WEST SUSSEX COUNTY COUNCIL CONSULTATION

TO:	Arun District Council FAO: Simon Davis
FROM:	WSCC - Highways Authority
DATE:	25 June 2019
LOCATION:	1-2 The Parade, Argyle Road, Bognor Regis, PO21 1DT
SUBJECT:	BR/125/19/PL Side & extension to existing mixed use building to provide additional retail space at ground level, 1 No. first floor studio flat & 2 No. studio flats to new roof extension.
DATE OF SITE VISIT:	N/A
RECOMMENDATION:	Advice
S106 CONTRIBUTION TOTAL:	£N/A

project title	1-2 Argyle Road, Bognor Regis	
drawing title	Proposed Ground Floor Plan

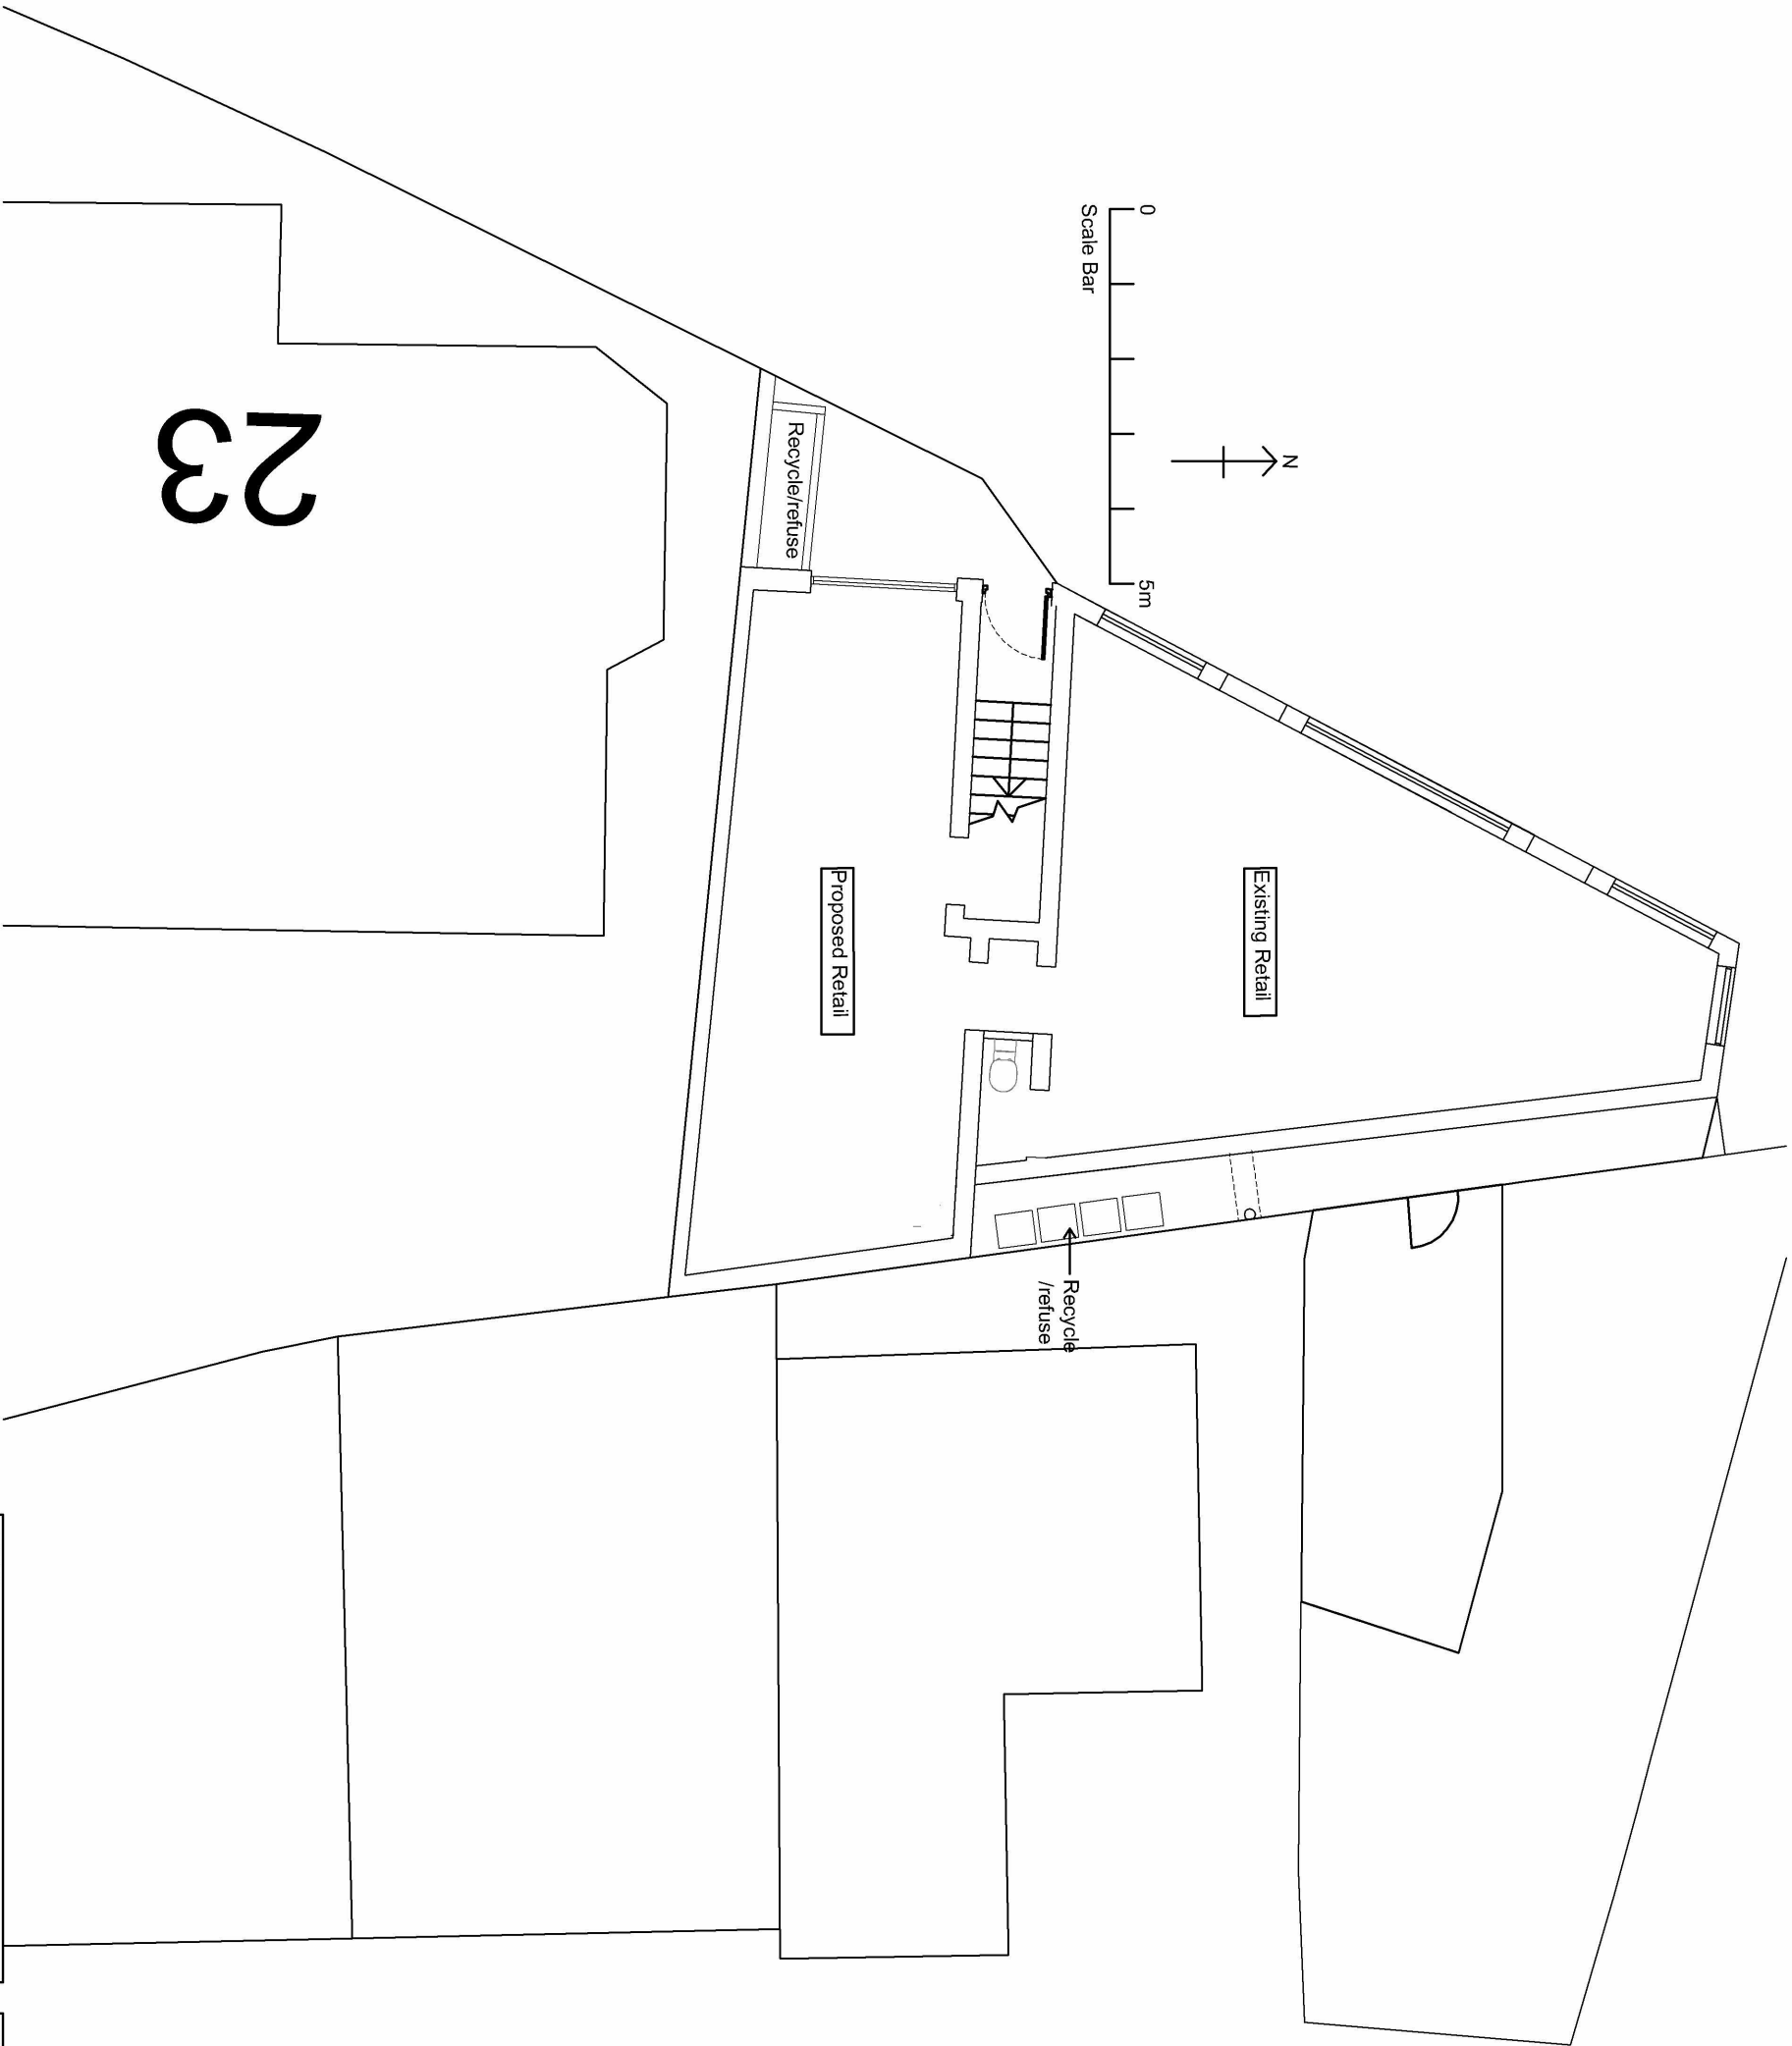
Cycling is a viable option in the area. Secure and covered cycle storage was not demonstrated in the plans. The inclusion of cycle storage in the plans increases the sustainability of the property by offering alternative modes of transport to the private car.

No part of the development shall be first occupied until covered and secure cycle parking spaces have been provided in accordance with plans and details to be submitted to and approved by the Local Planning Authority.
